Letter of Intent Site Development Plan

Black Cherry Investments LLC
1453 Woolsey Hts
Colorado Springs, CO 80915
Project Name: Gearhead Garage Inc.

Legal: Lot 9 Claremont Business Park Fil No 1A
Address: 1453 Woolsey Hts
Colorado Springs, CO 80915
Lot Size: 0.65 Acres
Zoned – CS-CAD-O
Parcel Number: 54081-01-031

1 SITE PLAN
 SCALE: 1"=20'-0"

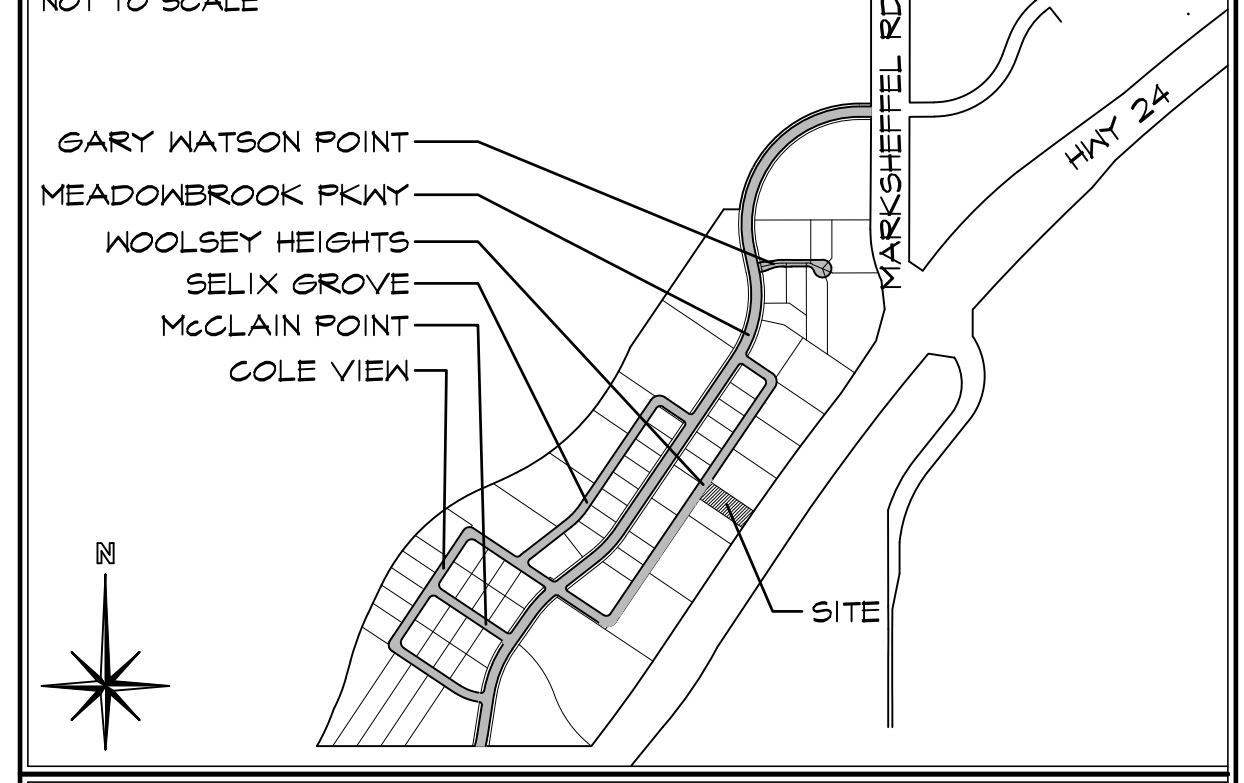
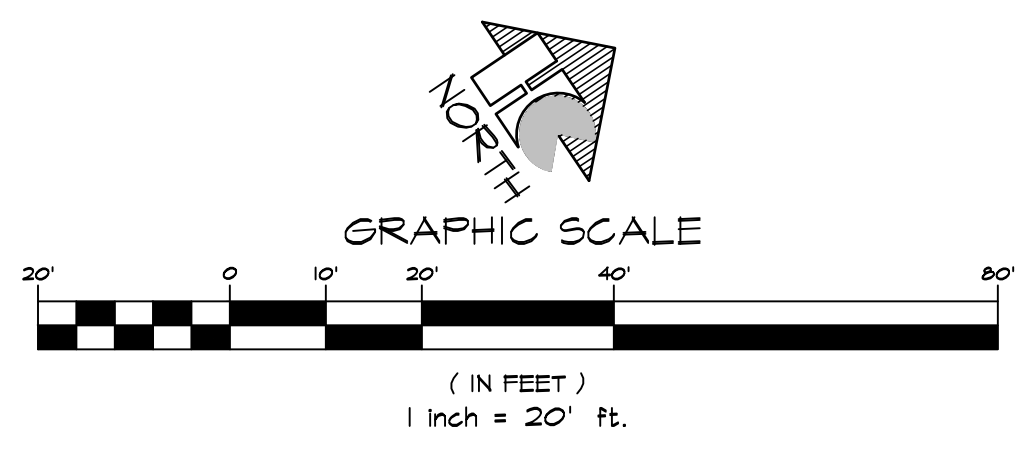
Applicant is required to apply for a driveway access waiver in accordance to plat note.
